Application no: H04-0232-11

Description: Proposed 3 bedroomed detached house

Location: 11A Station Street
Donington
Spalding
Lincs
PE11 4UQ
PE11 4UQ

Amendment: Amended parking/access arrangements (dwg. no.
09/MC/D/03C)

SCALE
1:100
DRAWING NUMBER
09/MC/D/03

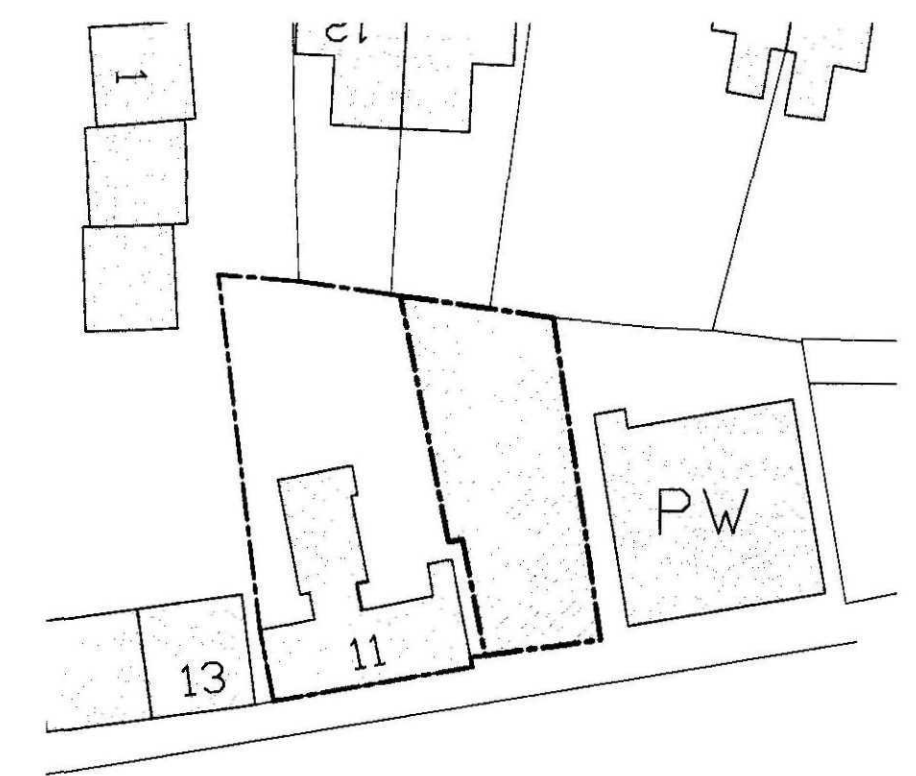
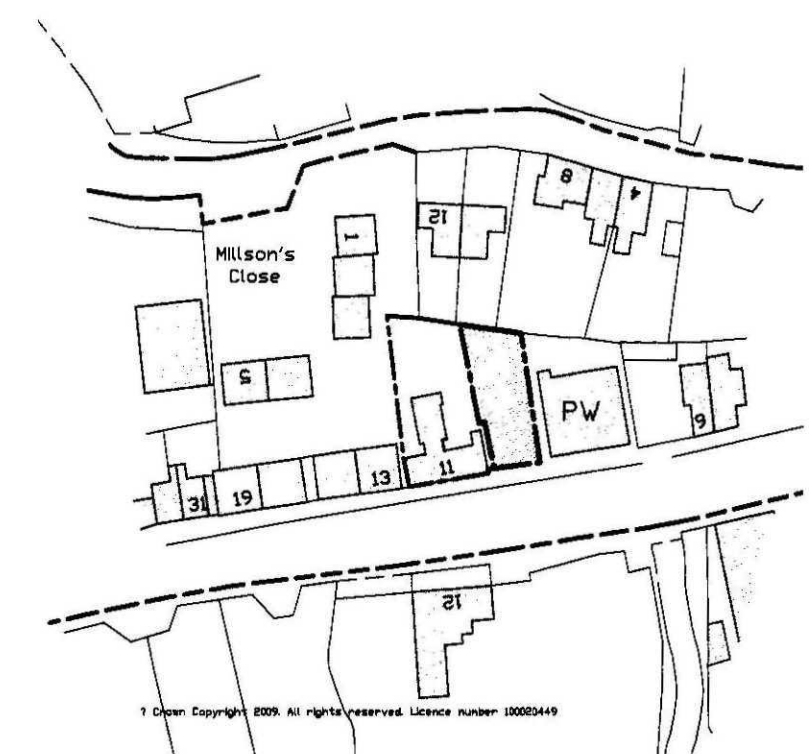
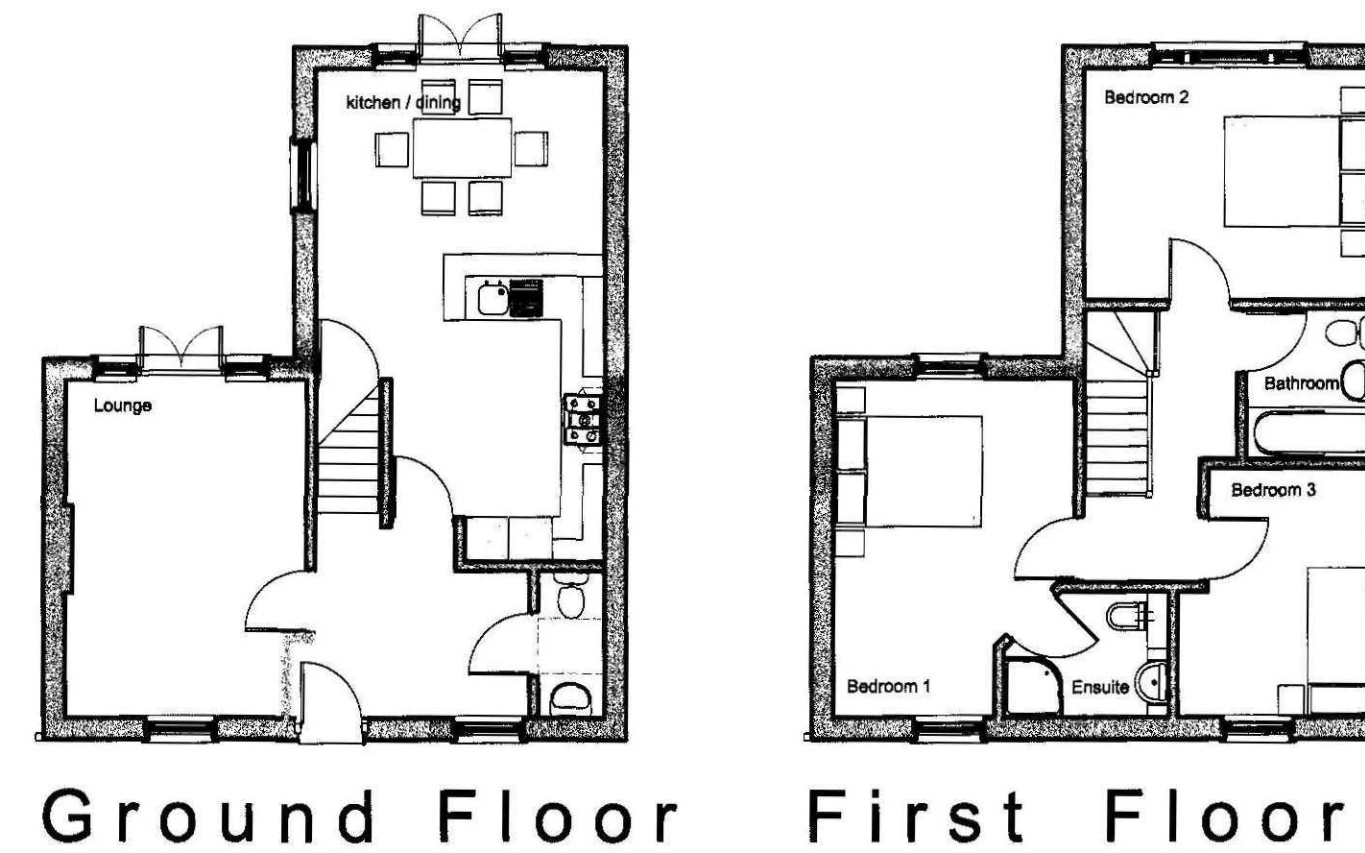
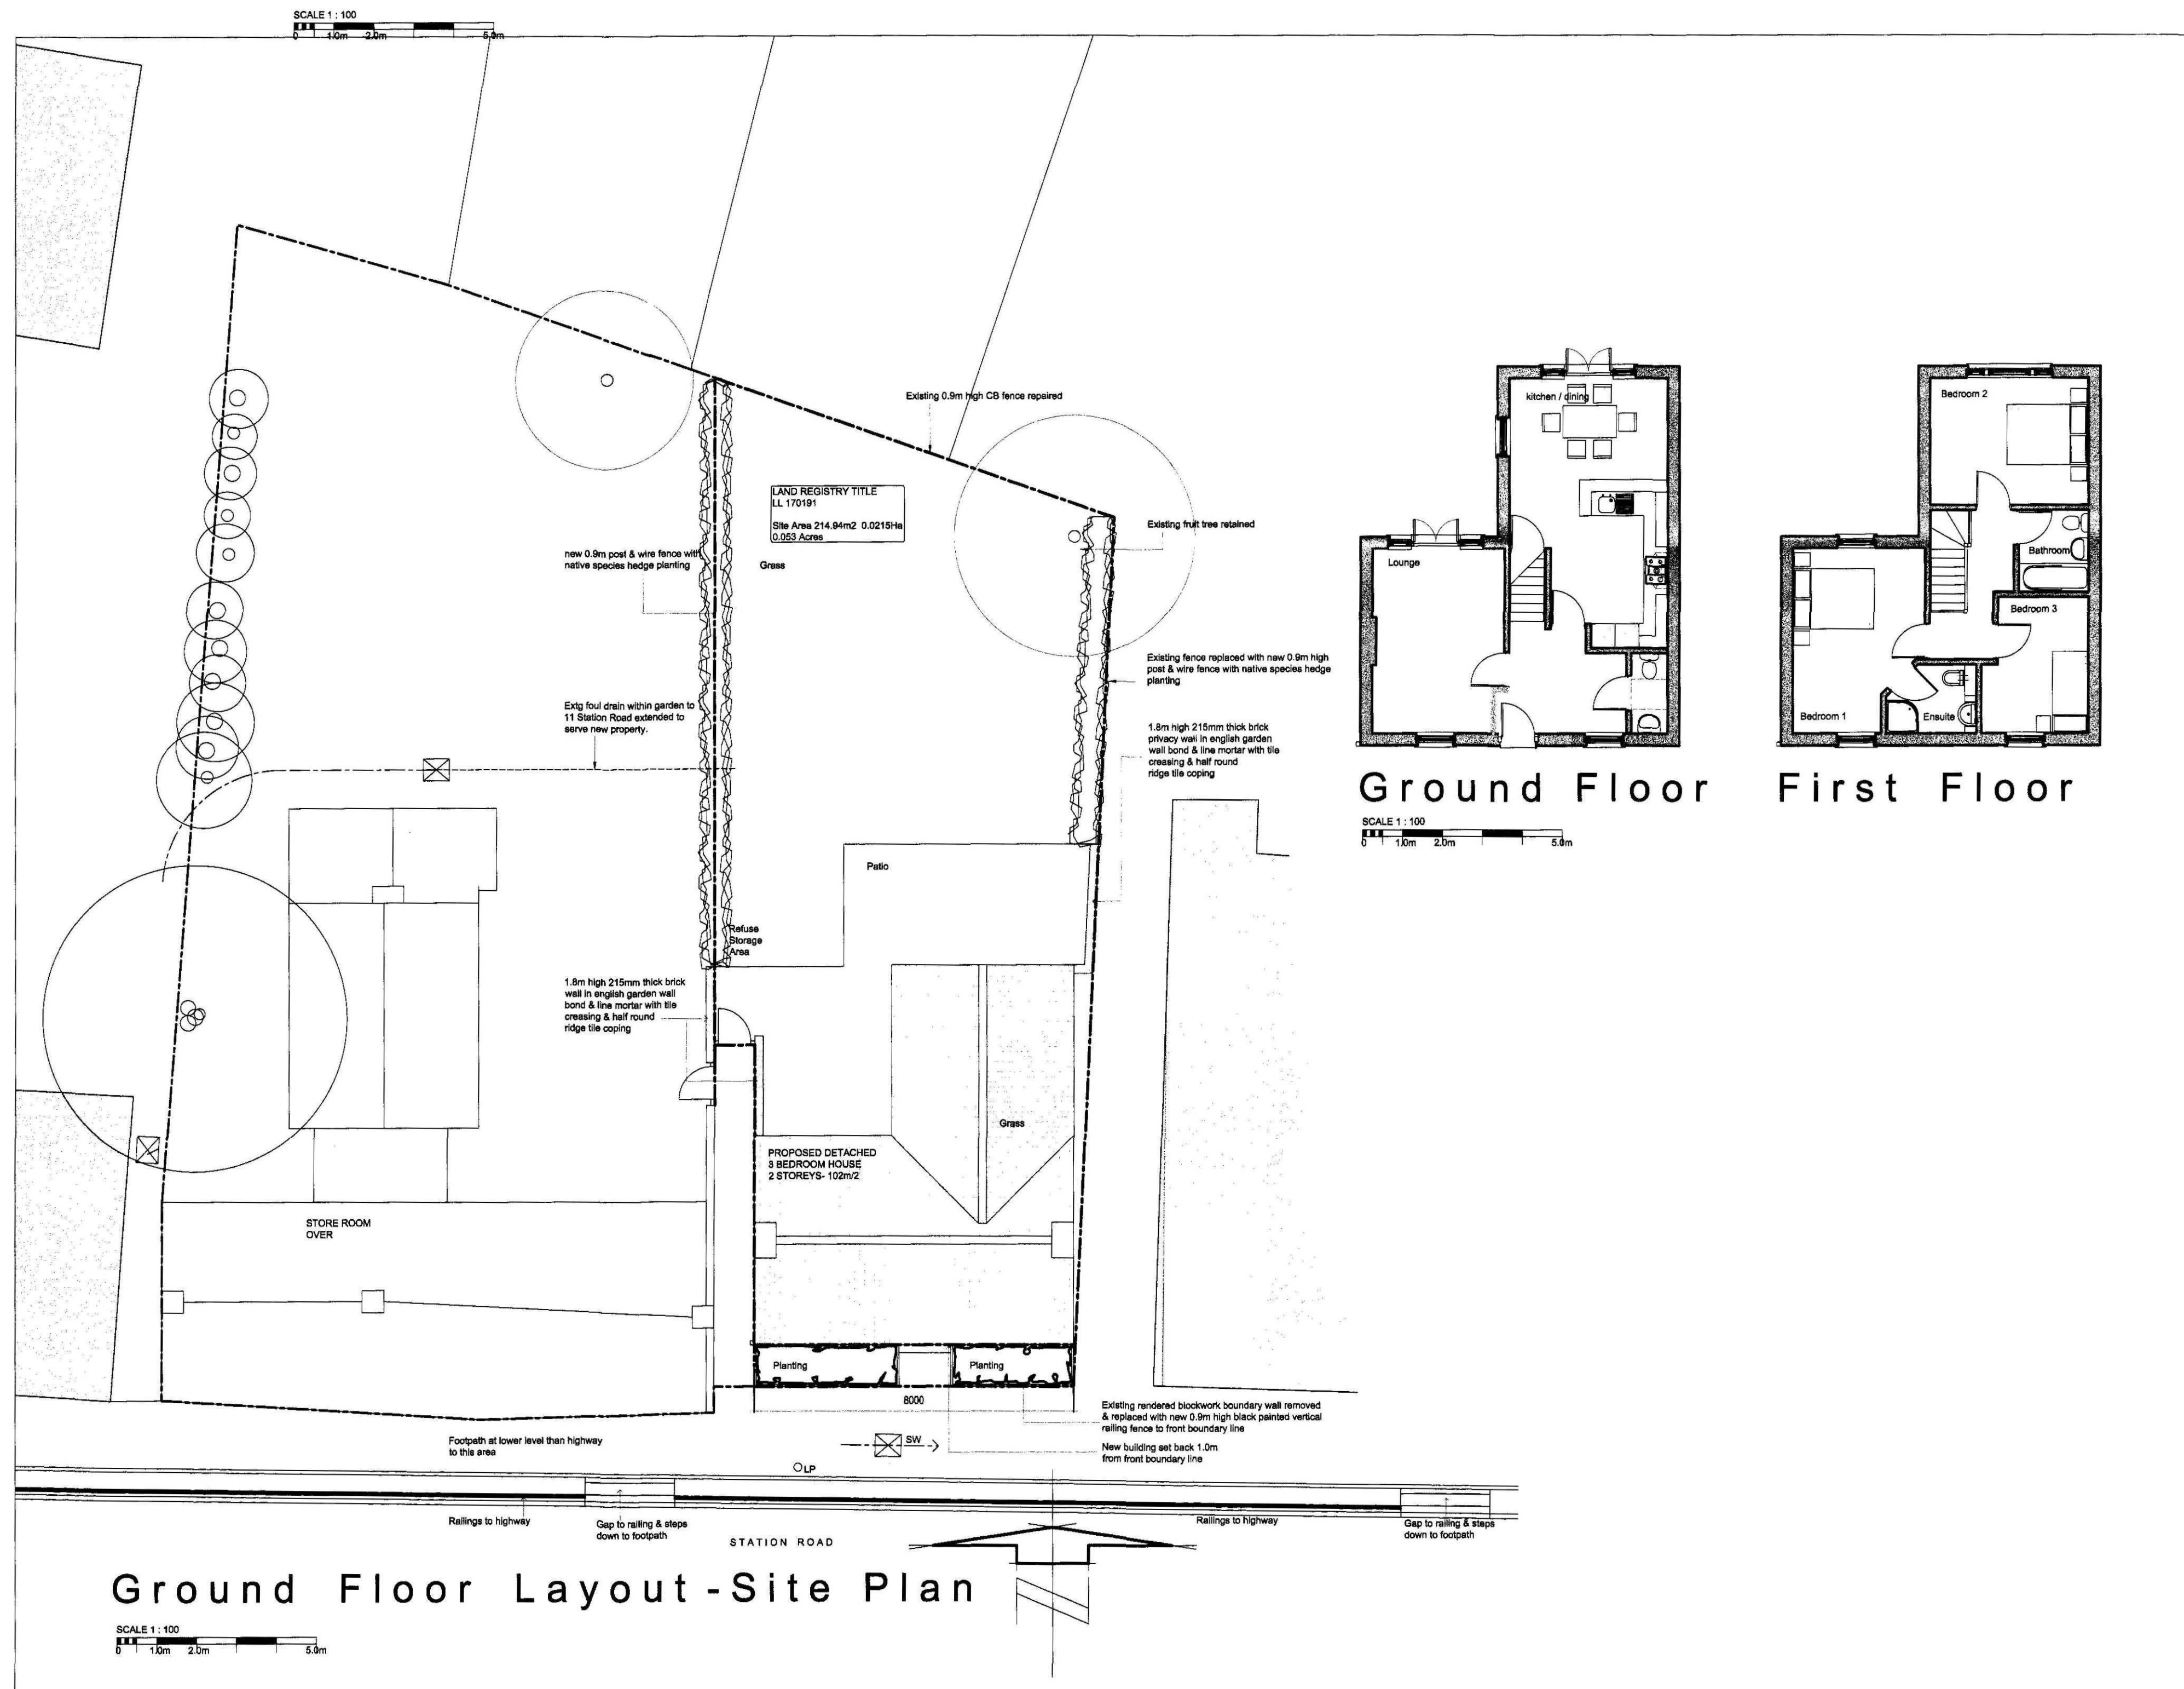
I have taken the opportunity to revise the drawing further, indicating the location of the two gaps in the railings in relation to the front door of the proposal to show that parking and access should not be a major issue. I would be obliged therefore if this drawing can be taken as a further amendment to the application drawing previously submitted.
